Colby Company, LLC

LUTHER BONNEY ENERGY UPGRADES ADDENDUM #1 MARCH 15, 2012

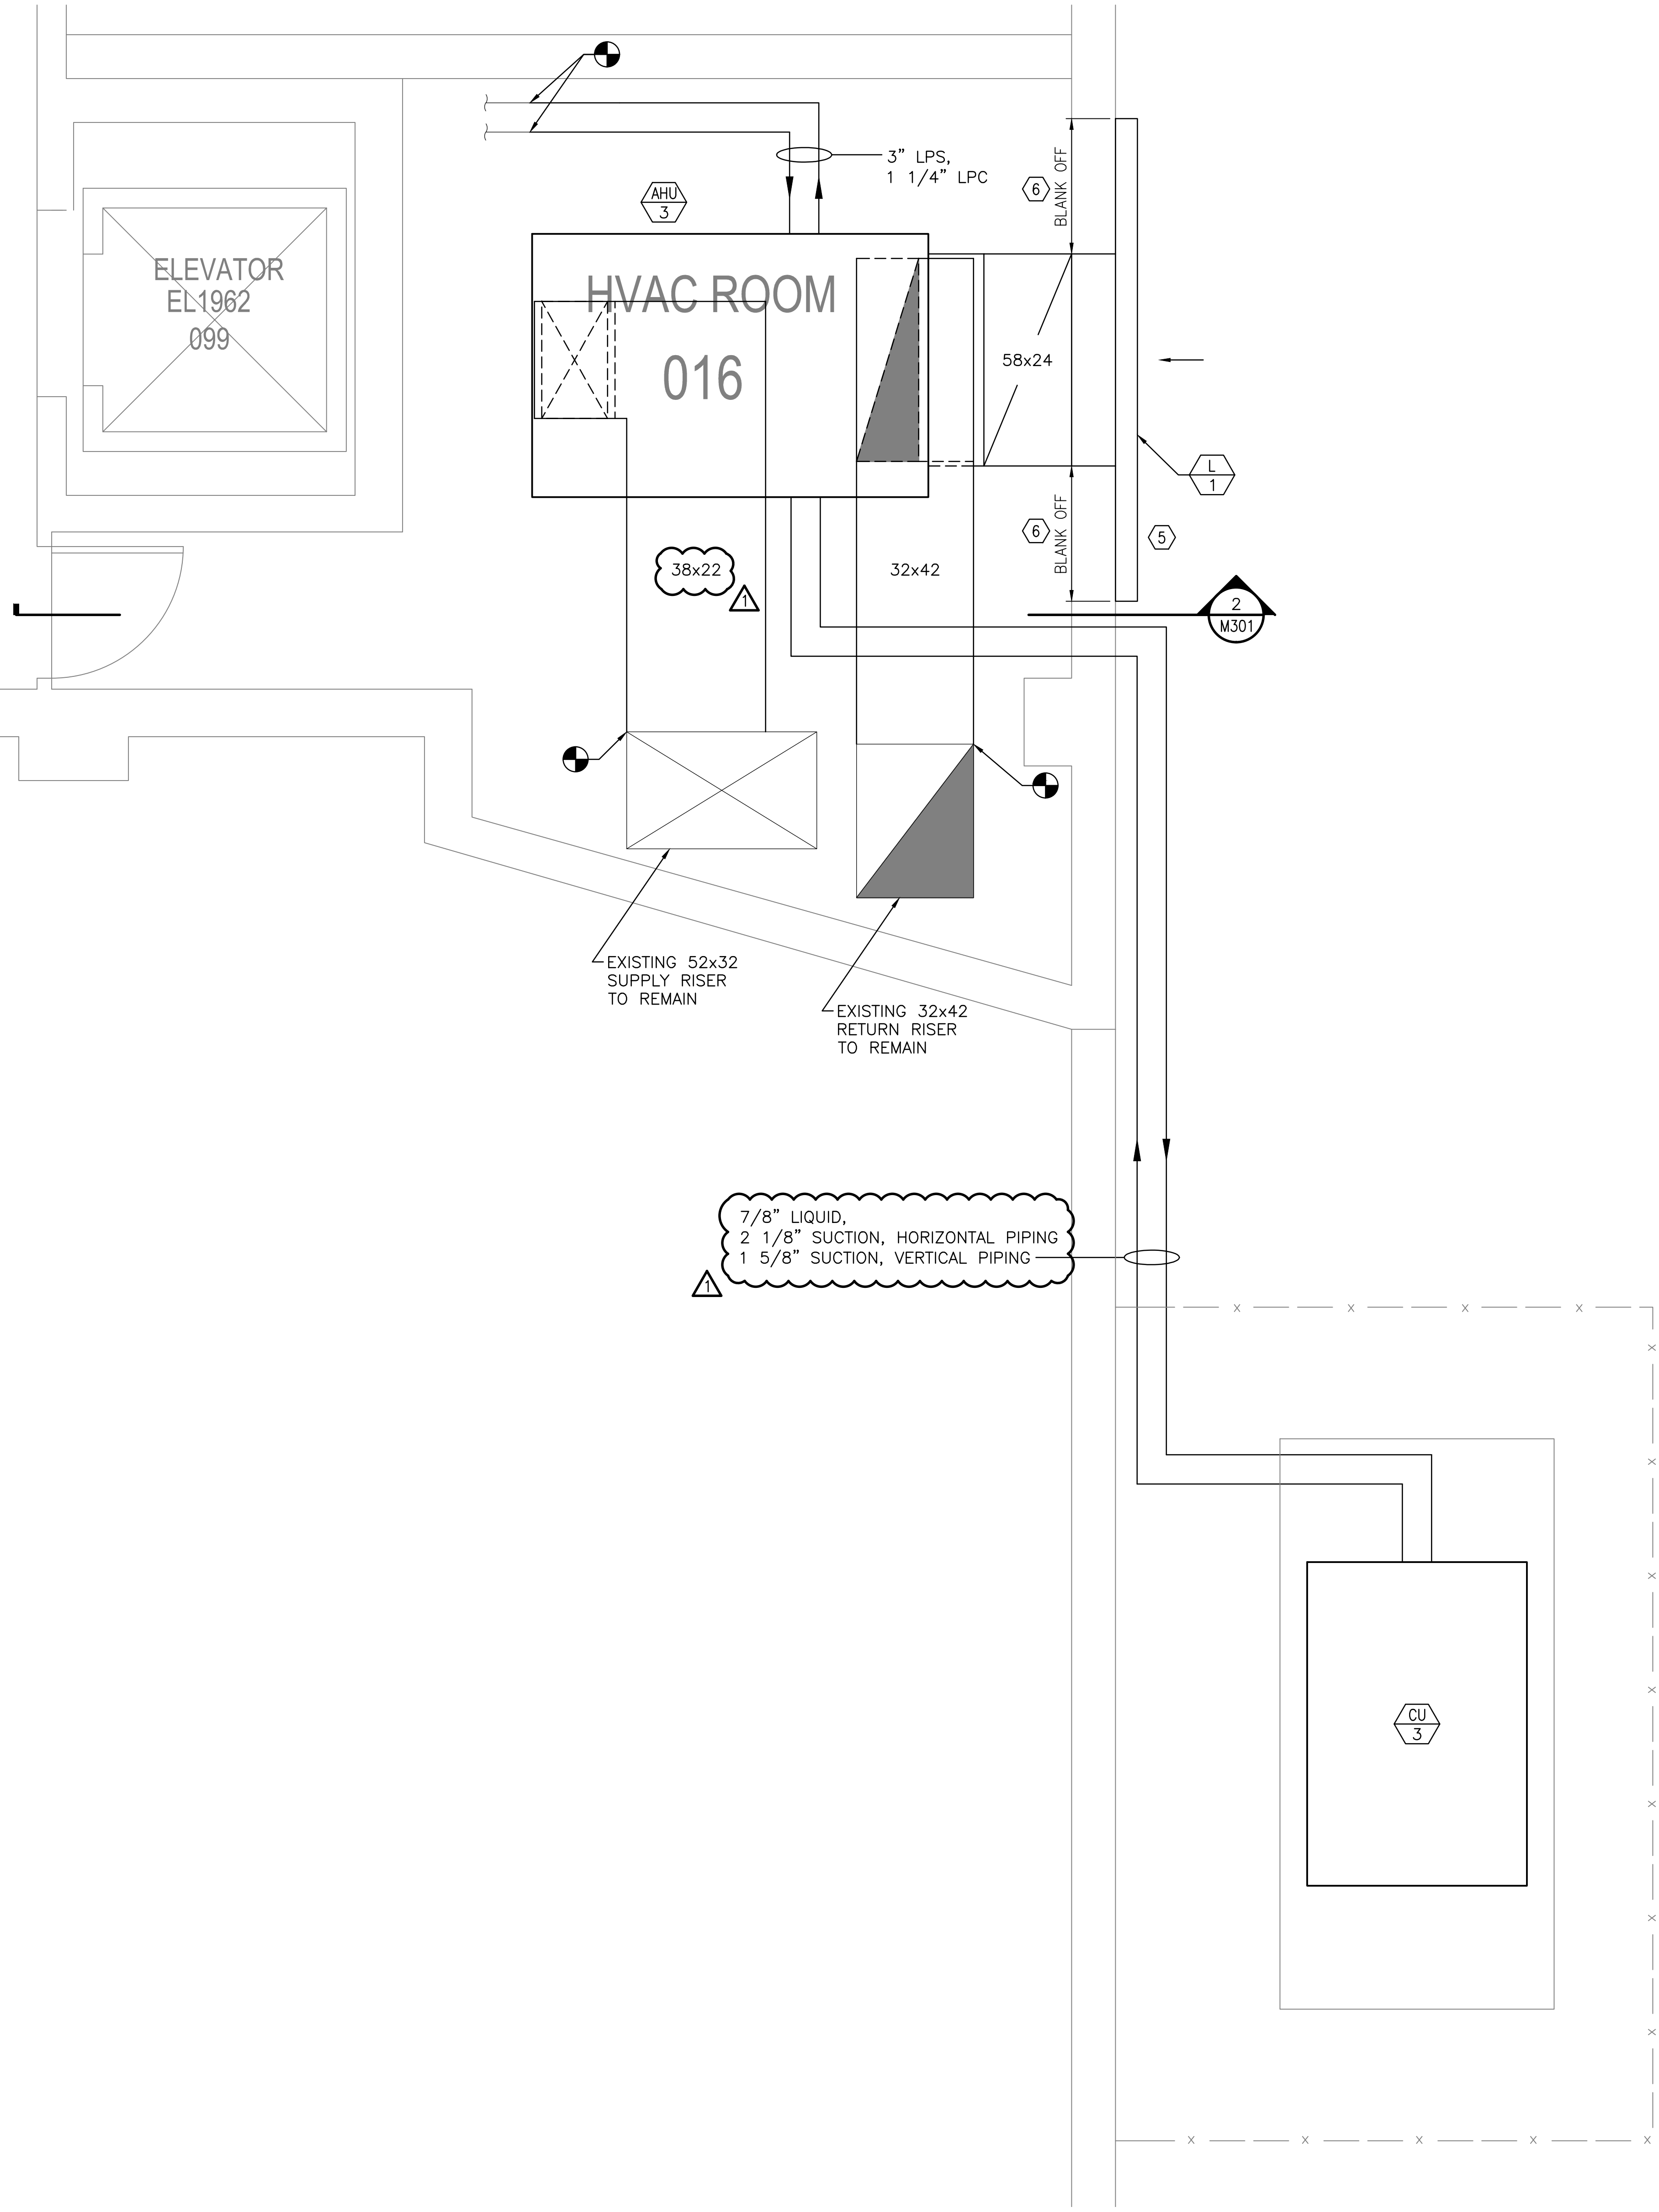
- The Lower Roof is EPDM manufactured by Carlisle
 - The Upper Roof is EPDM manufactured by Firestone
5. Drawings M-100, M-102, and M-103 have a Note which says "Replace all steam traps in kind". Please clarify how we are to determine the quantities/scope of work for this item.

- Addendum #1 Appendix B has original building drawings with steam traps highlighted. These steam traps will need to be replaced in addition to the steam traps associated with equipment already to be replaced (AHUs, etc.)

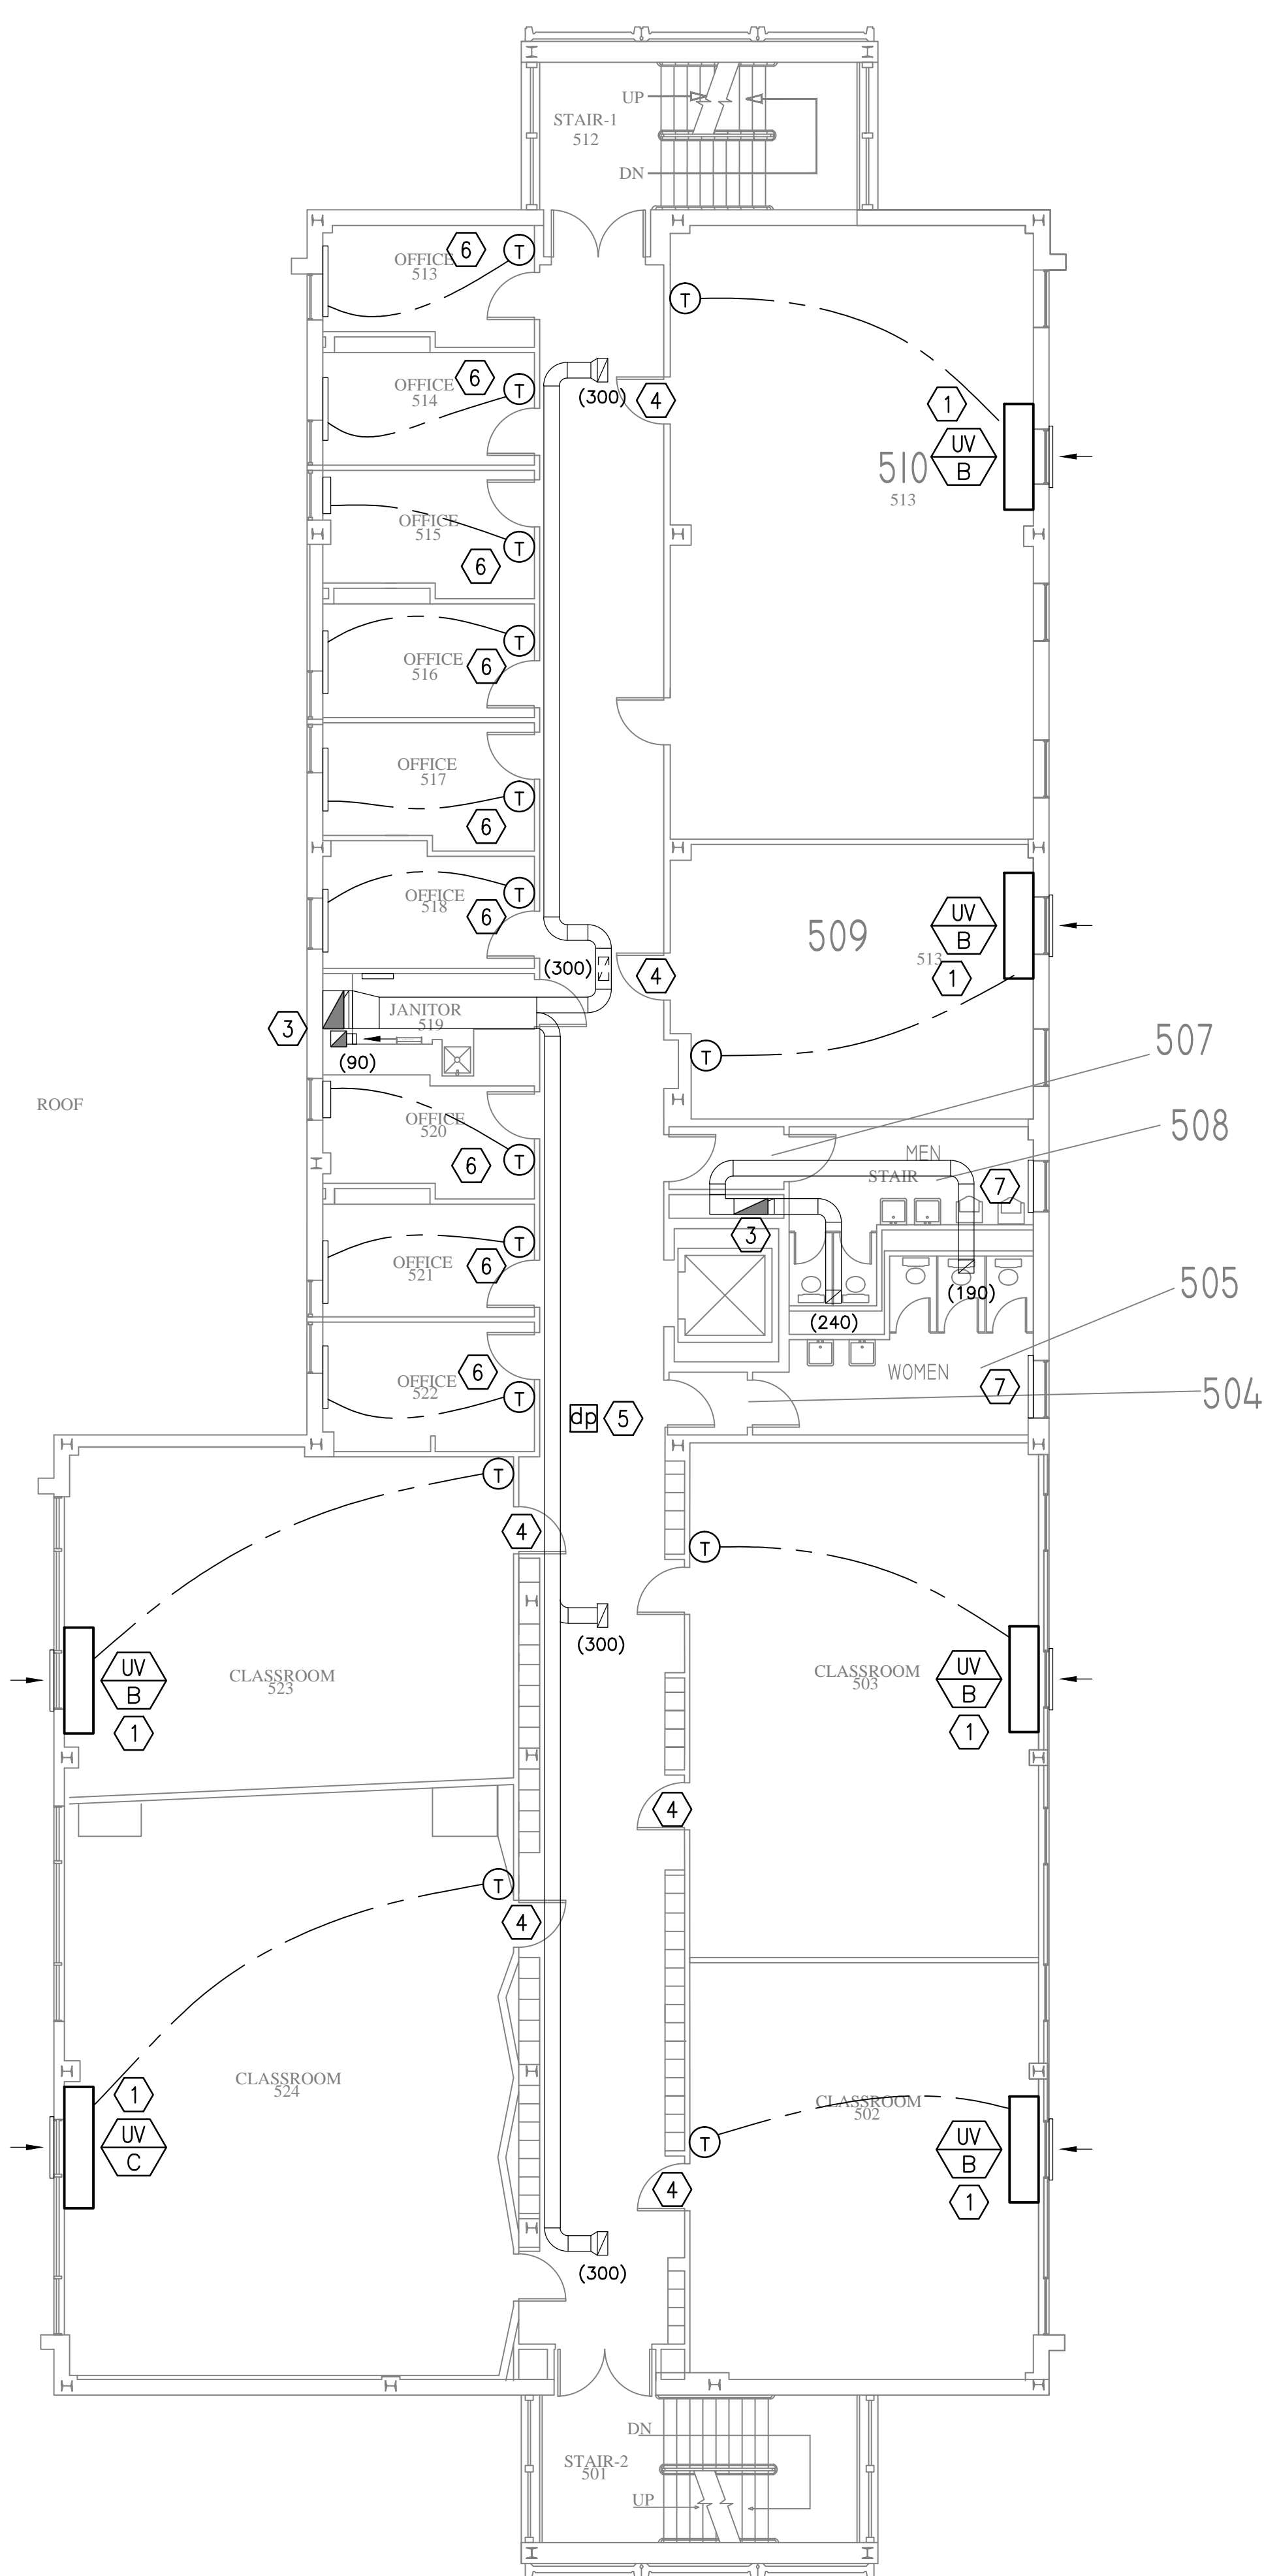
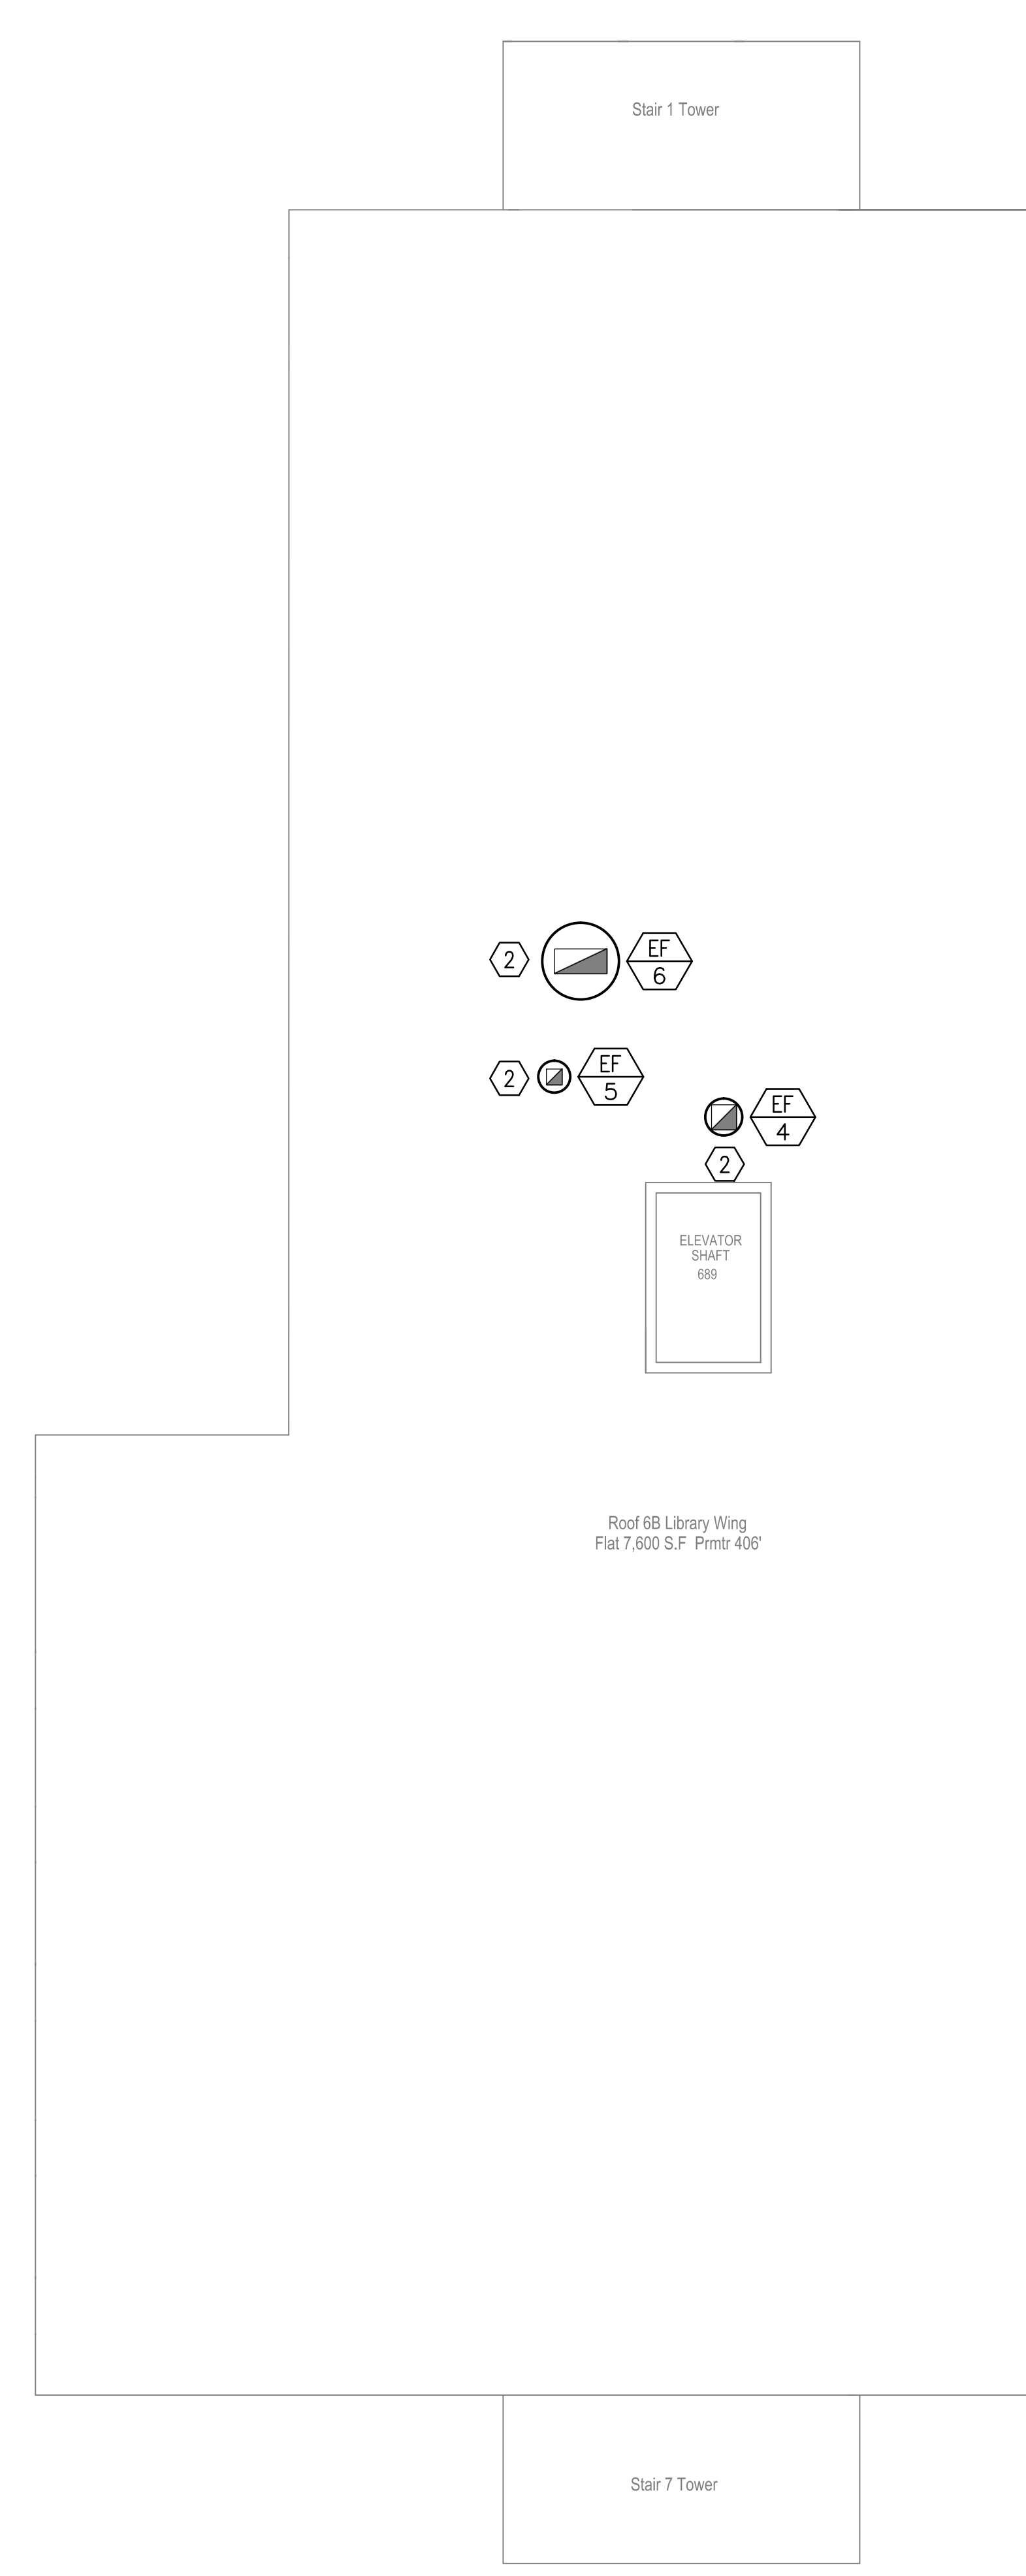
4. Drawing M-104 has a note to perform roof work in accordance with the existing warranty, as related to the new exhaust fans. Please provide the name of the roof manufacturer so we can properly select the correct roofing details.
